**HERITAGE ADDENDUM  
(SD 17\_8665)**

**MERCANTILE HOTEL**

**25-27 GEORGE STREET,  
THE ROCKS 2000**

Urbis has been engaged by Welsh & Major to prepare the following heritage addendum pertinent to the refurbishment works and rooftop terrace proposed at the Mercantile Hotel, The Rocks (SSD 17\_8665).

SSDA.101

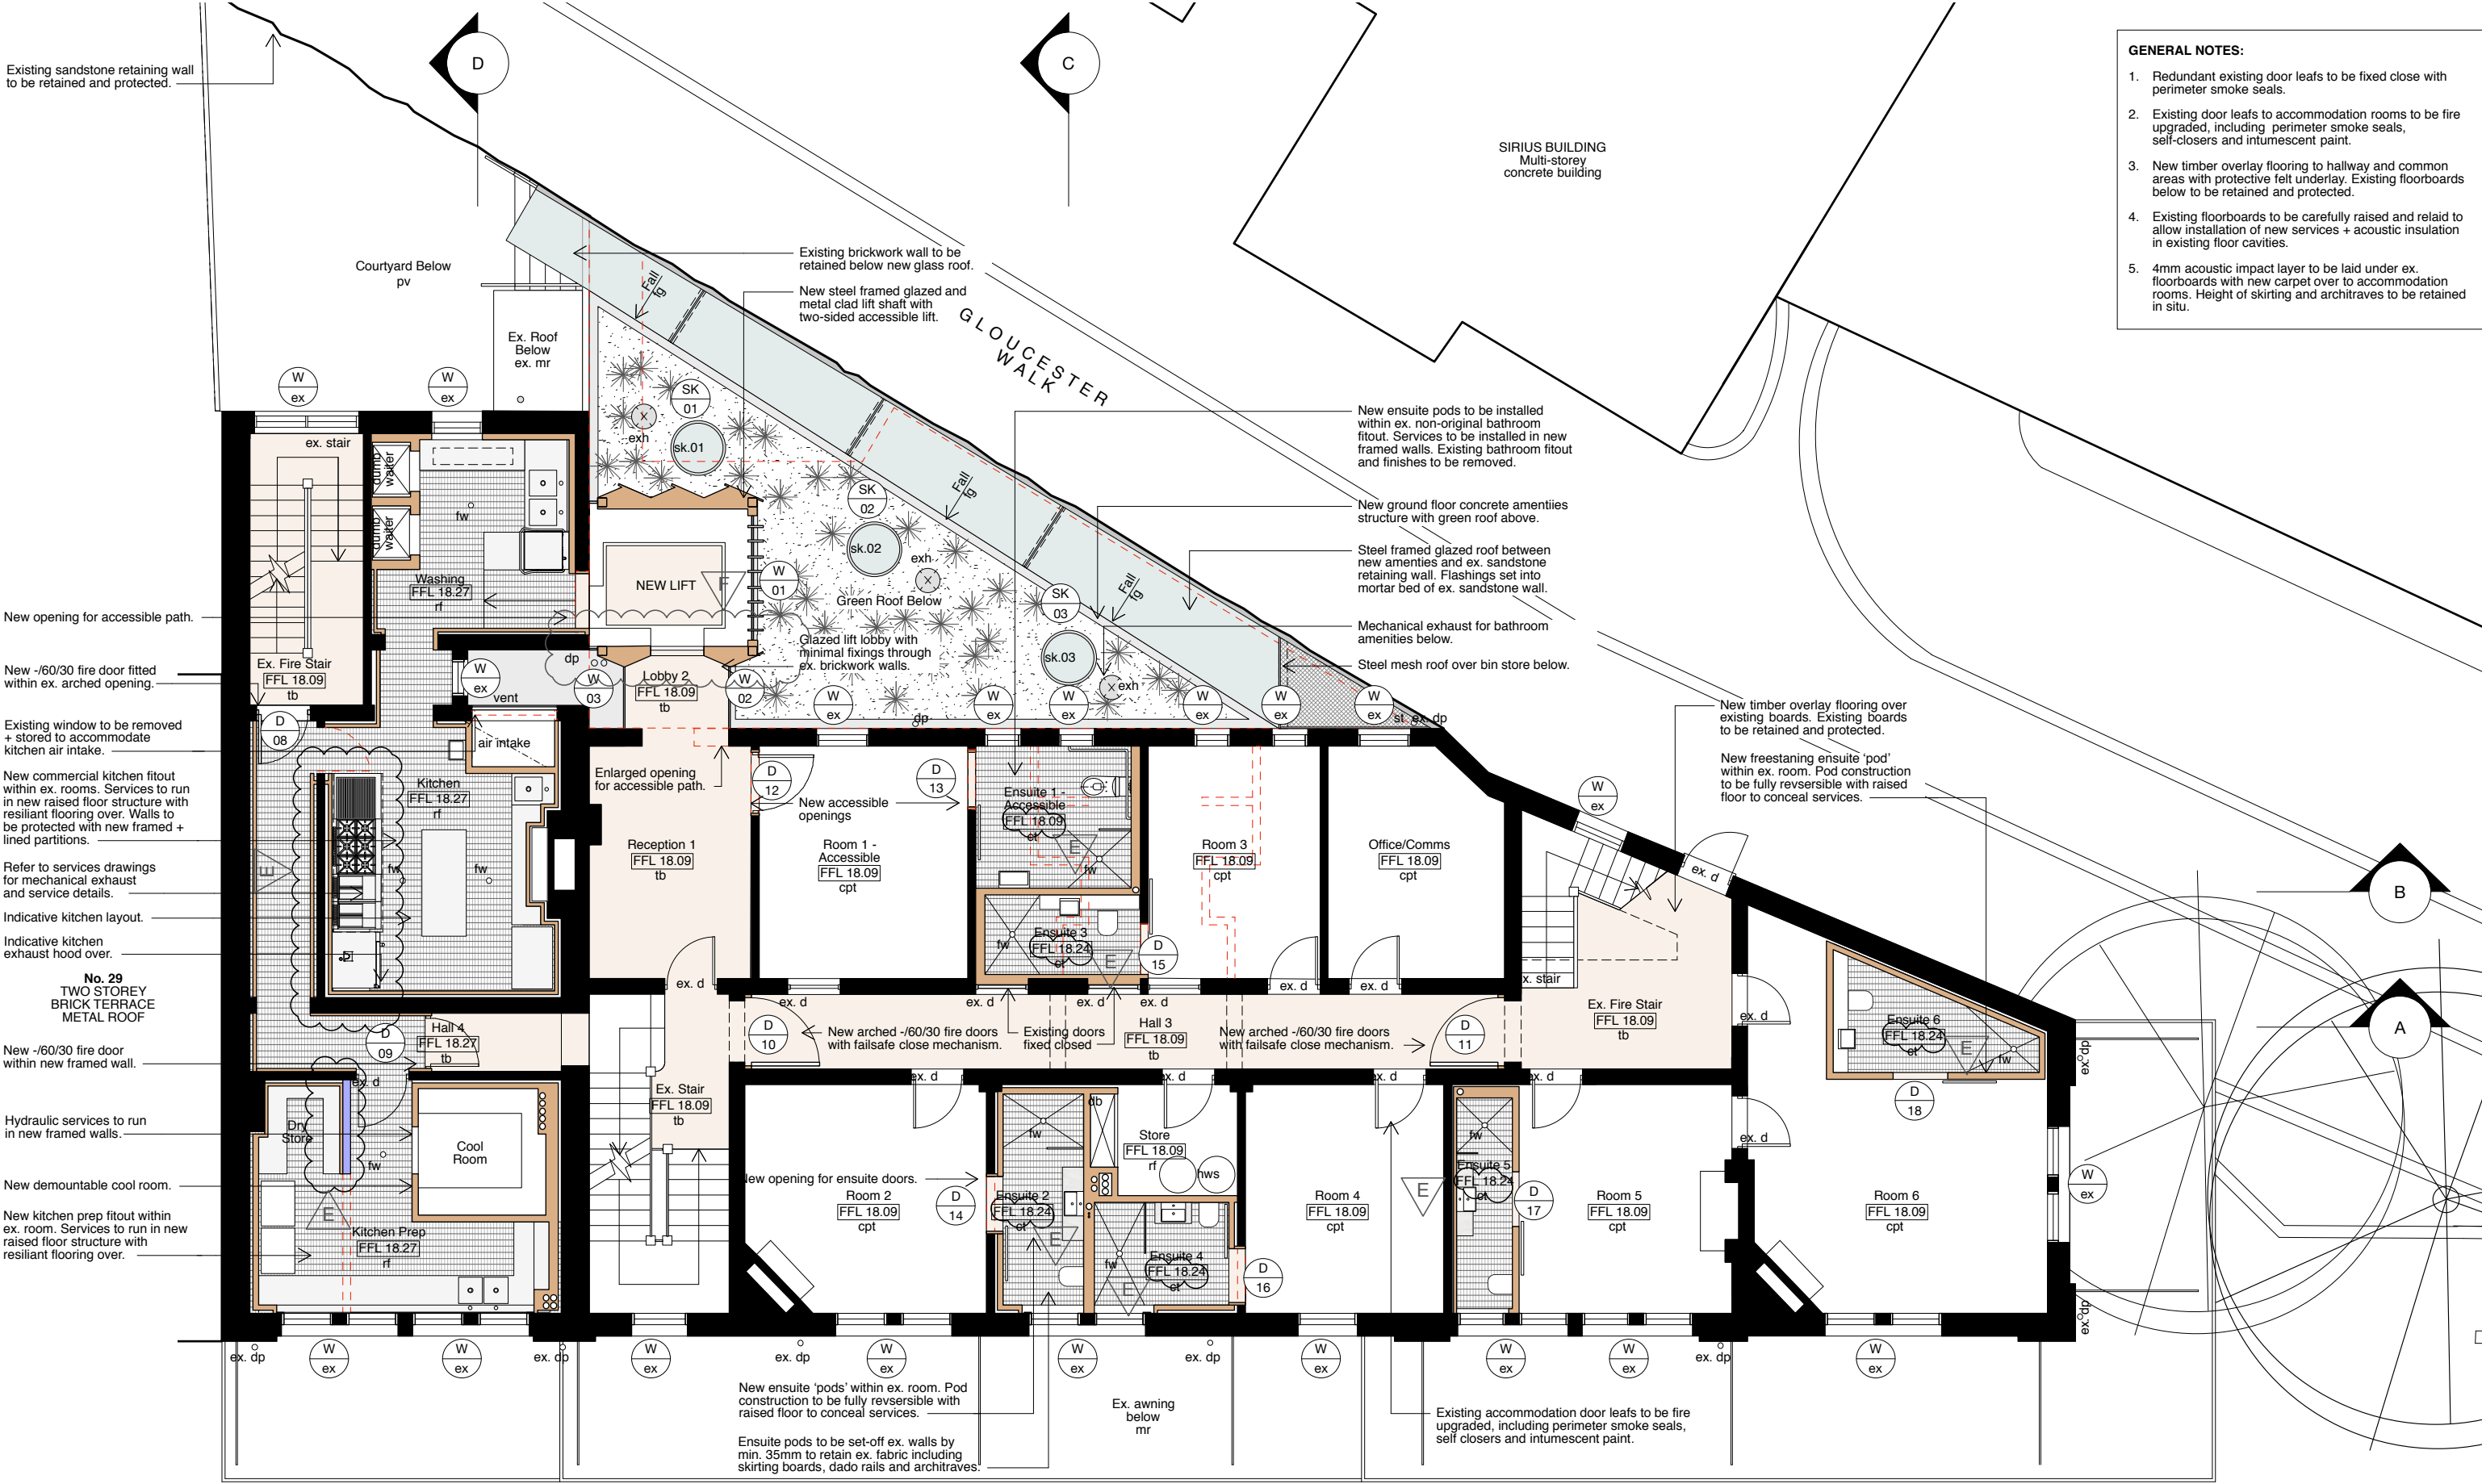
- *Proposed changes to the ground floor main bar and how this will retain and enhance the existing bar character.*

- *Proposed changes to the ground floor main bar and how this is retaining/enhancing the existing bar character and atmosphere.*

- Existing bar fit out is to be retained, with refinishing and repair to timber panelling.
- Existing floor boards to be retained and protected with new timber overlay floor installed over.

The proposed works to the ground floor main bar have been designed to retain and enhance the significance of this central area in the building. The extant floor boards are to be retained and protected, it is proposed that a new timber overlay is installed over this element. The retention and protection of the extant timber flooring has been assessed as a positive heritage outcome. This fabric would be retained and protected, and would allow for an updated floor finish in a heavily trafficked location. It is proposed to retain, refurbish and

In order to facilitate the installation of the new services risers for the upper floor bathrooms the columns located within the ground floor bar area would be enlarged. In order to mitigate against any undue impact to the visual presentation of the main bar area the enlargement of the columns would match the existing cornice and dado detailing. It is understood that the service risers are required to be installed in order to facilitate necessary refurbishment works at the site, the proposed treatment would be acceptable from a heritage perspective and has been assessed as sympathetic to the significance of the site.

Drawing No.
SSDA.303

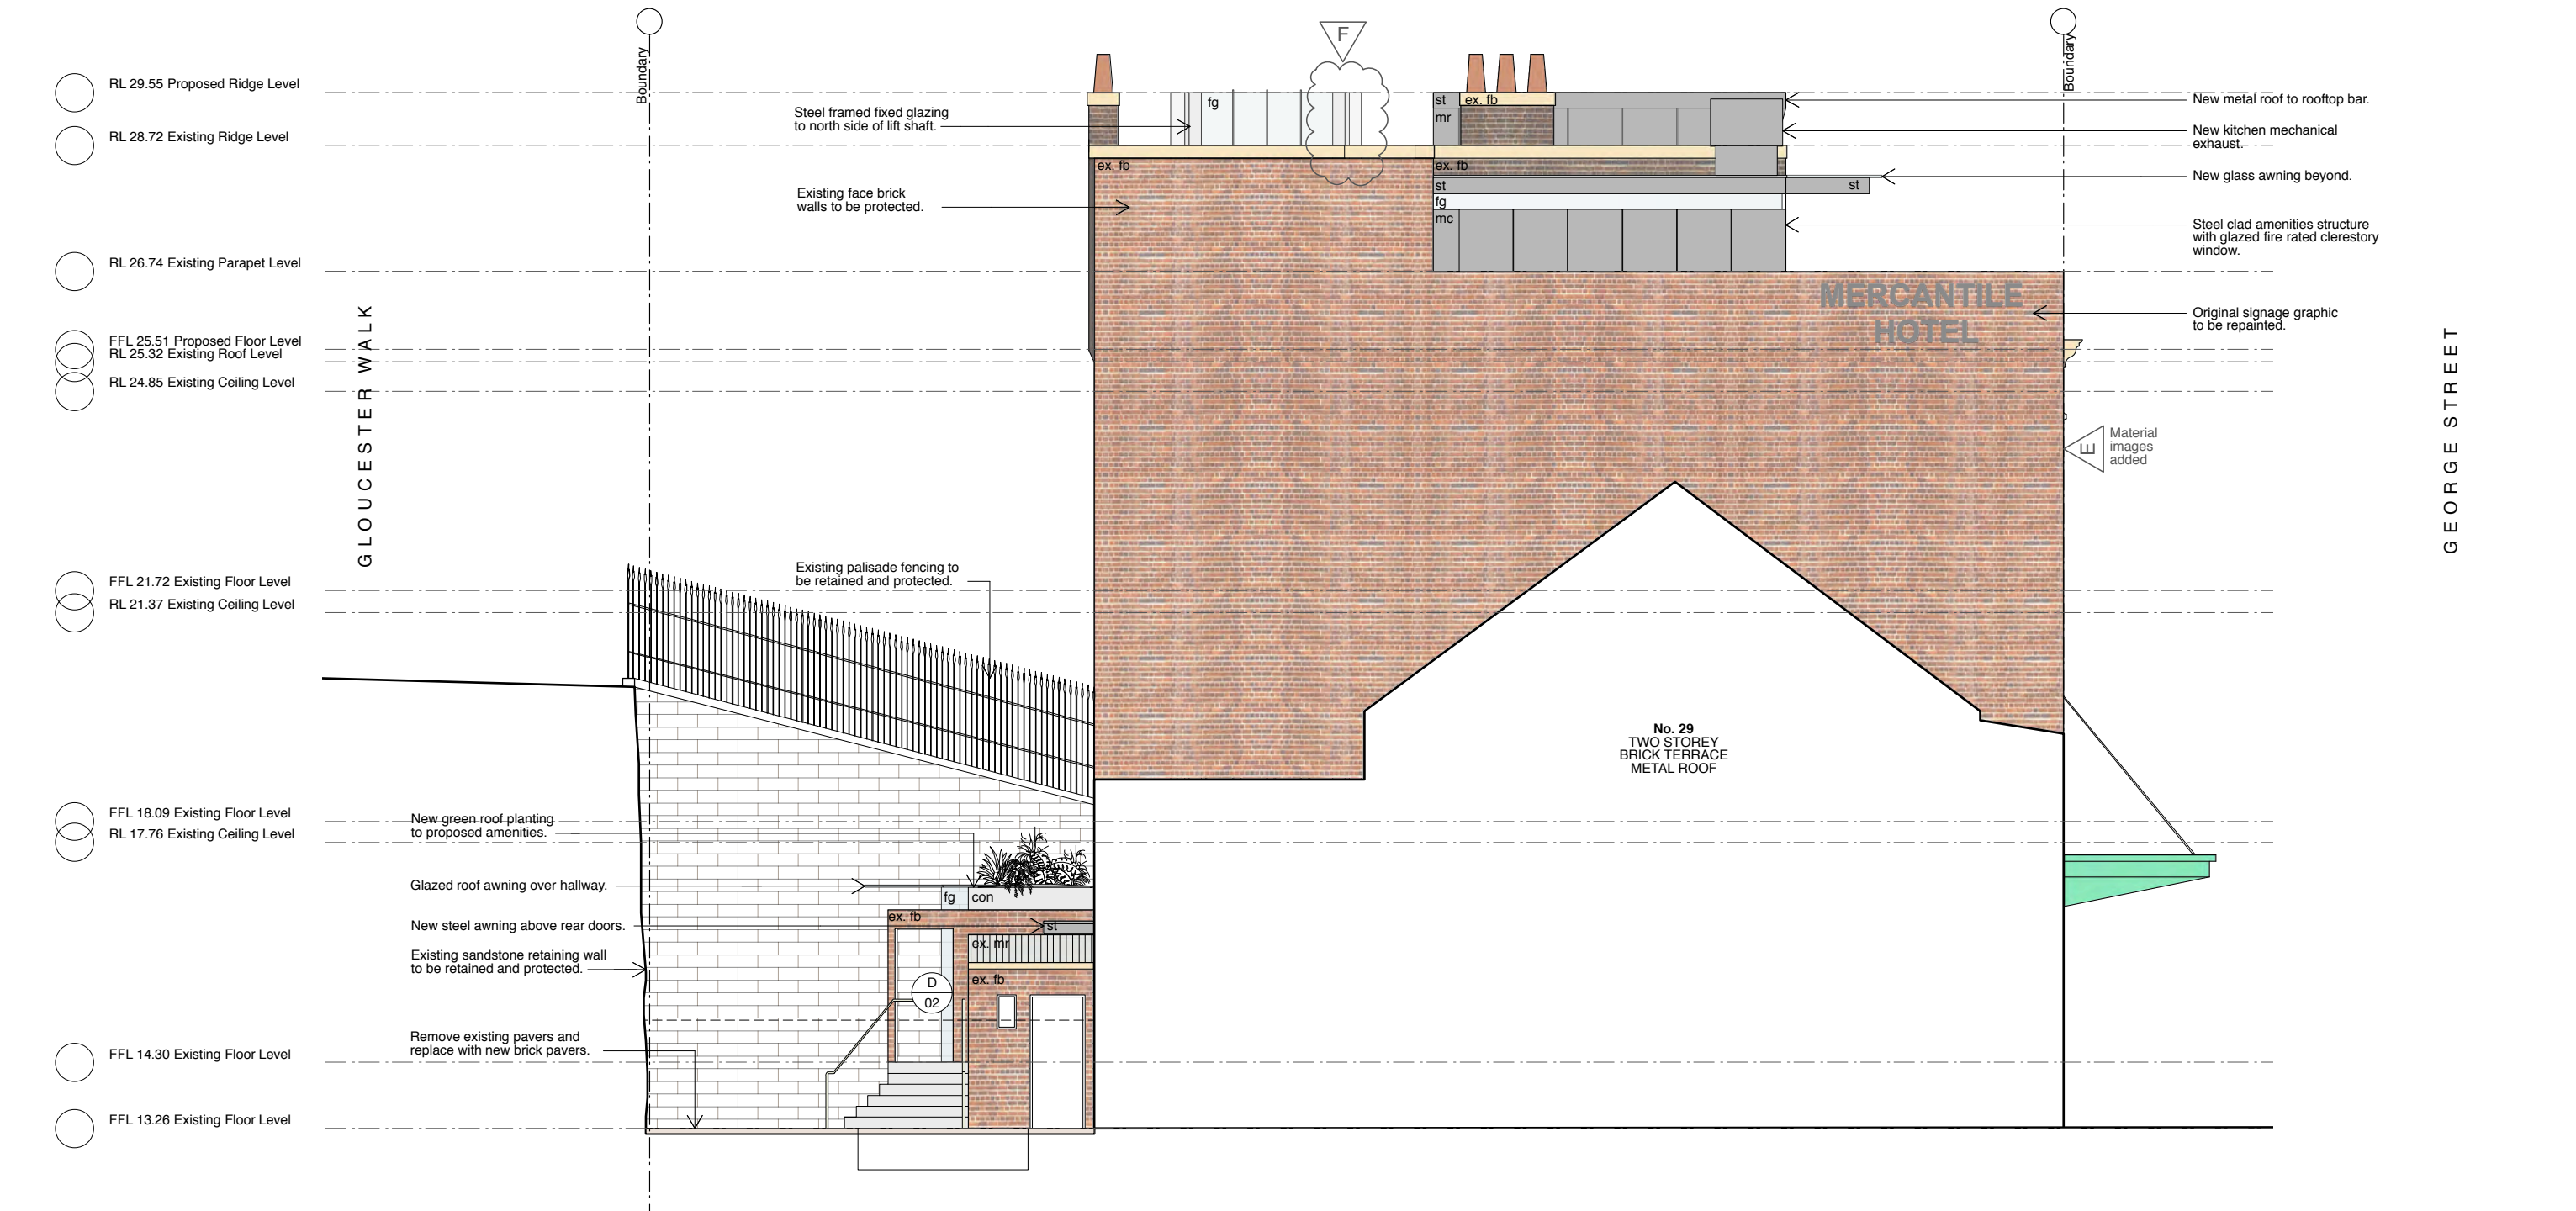
The Heritage Impact Statement (p. 71) advises that the ensuites will be inserted as pods. There is concern that the Heritage Impact Statement underestimates the actual physical impacts of the structural work and services. Therefore, detailed sections of the proposal wet areas, ensuites, kitchen, new bars should be requested to show how the new false walls, floors, ceilings and fitouts will be constructed, supported and stiffened including their interface and impact on the existing floors, existing timber joinery, skirtings, doors and windows, their architraves sills etc. and any plaster decoration.

*Information should be submitted to show how the roof levels, roof floor structure, stormwater drainage and trafficable surfaces will be resolved, taking into account structural and code compliance, the existing floor levels and the outdoor terrace.*

The proposed air-conditioning system is an external compressor and internal air handling unit with reticulation pipes only within identified service runs, not ducted. The air-conditioning units would be installed above the ensuite pods with outlet and return air servicing two rooms per pod installation. The proposed penetrations have been assessed as acceptable from a heritage perspective. The installation of air-conditioning units is required to update the accommodation rooms at the site in line with expectations of contemporary patrons and to facilitate the ongoing historic use and occupation as accommodation rooms. As the proposal seeks the retention of the accommodation rooms located at site, this intervention has been assessed as acceptable from a heritage perspective.

Refer further to the updated architectural package showing detailed resolution of all floor levels and integration of new services that has been resolved in detail in collaboration and based in the advice of Urbis Heritage (heritage consultant/heritage architect). It is understood that the proposed levels have been resolved remain largely the same as the existing internally generally. Where new bathroom ensuites are located a new floor structure (set up) is installed to allow required falls and servicing to be located without any change to the existing floor structure and minimal (pipe penetration only) intervention to the existing floor making them largely reversible. Externally the roof level which is wholly obscured externally by parapet walls consists of a new floating trafficable surface that sits on top of the existing to facilitate the existing drainage system to be retained and minimal intervention. These works have been assessed to be acceptable from a heritage perspective with minimal impact to fabric of lower significance being floors (currently carpeted)
